From: Iqraa Malik [redacted]
Sent: 15 July 2020 10:00
To: Sian Eggington [redacted]
Subject: FW: Request for further information BE/52/20/HH
Attachments: We sent you safe versions of your files; Site Location.pdf; cil.pdf
Categories: Green Category

This application is for 3 Berghestede Road.

Proposed Side Extension & Loft Conversion
Plans and Elevations
Planning
Date
June 2020
Scale
1:200 1:1250

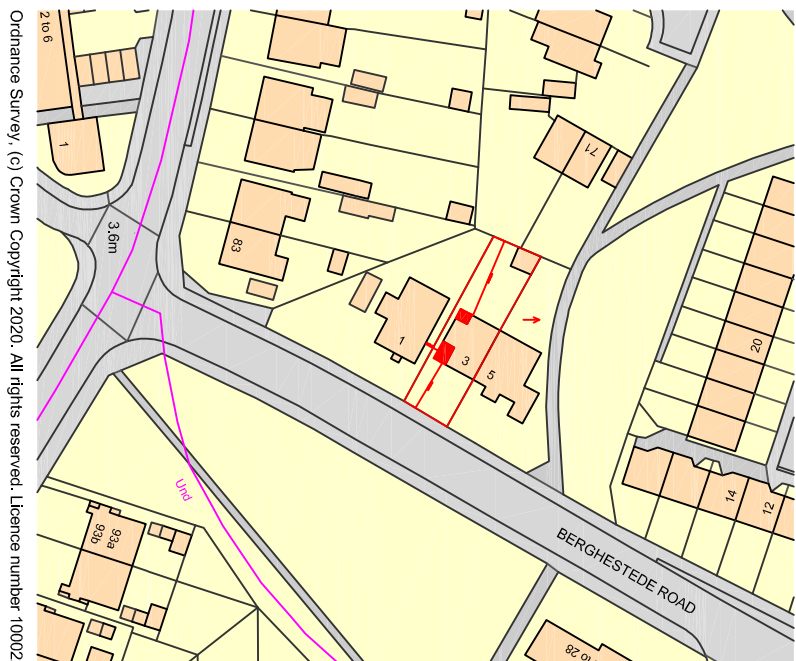
Block Plan Dimensions: You are required to include dimensions on the block plan from the proposed extensions to all site boundaries.
